EL PASO COUNTY PLANNING AND COMMUNITY DEVELOPMENT DEPARTMENT

STORMWATER MANAGEMENT PLAN CHECKLIST

Revised: July 2019

project 119461	contract
drawing CE101	rev. 2
sheet 30	of sheets
file 119461_CE101.DWG

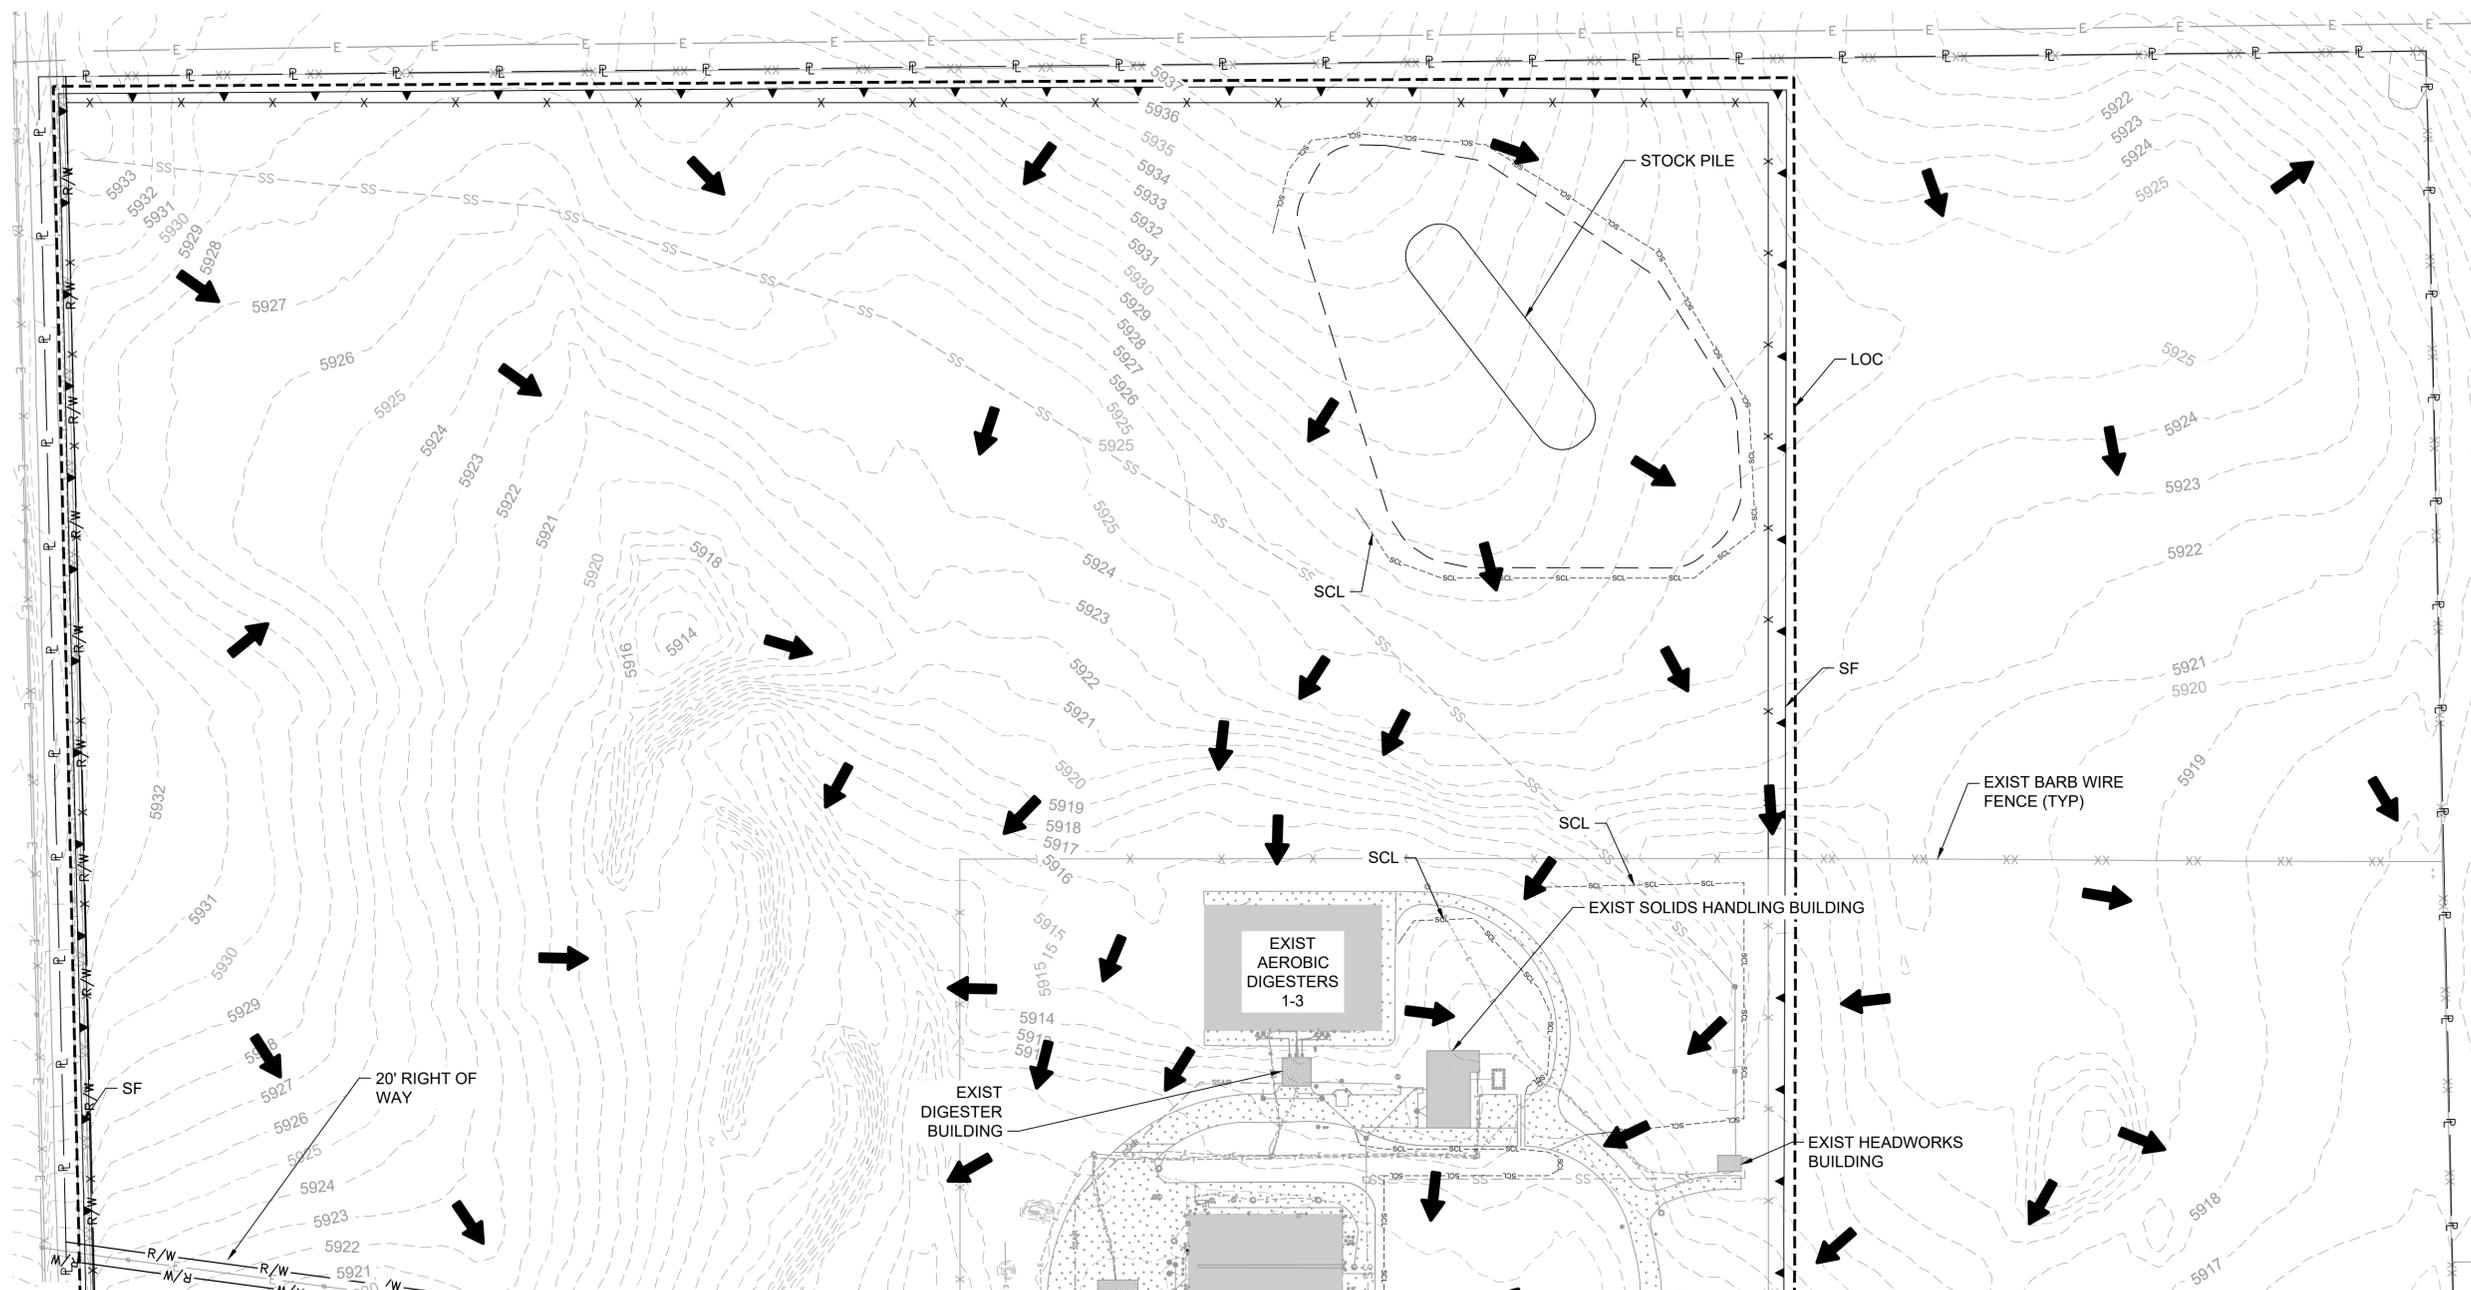
Applicant	PCD
17g	location of all structural control measures Show/notate location of ECB on plans		X
17h	location of all non-structural control measures	X	✓
17i	springs, streams, wetlands and other surface waters, including areas that require maintenance of pre-existing vegetation within 50 feet of a receiving water	X	✓
18	Narrative description of all structural control measures to be used. Modifications to EPC standard control measures must meet or exceed County-approved details.	X	✓
19	Description of all non-structural control measures to be used including seeding, mulching, protection of existing vegetation, site watering, sod placement, etc.	X	✓
20	Technical drawing details for all control measure installation and maintenance; custom or other jurisdiction's details used must meet or exceed EPC standards	X	X
21	Procedure describing how the SWMP is to be revised	X	✓
22	Description of Final Stabilization and Long-term Stormwater Quality (describe nonstructural and structural measures to control SW pollutants after construction operations have been completed, including detention, water quality control measure etc.)	X	✓
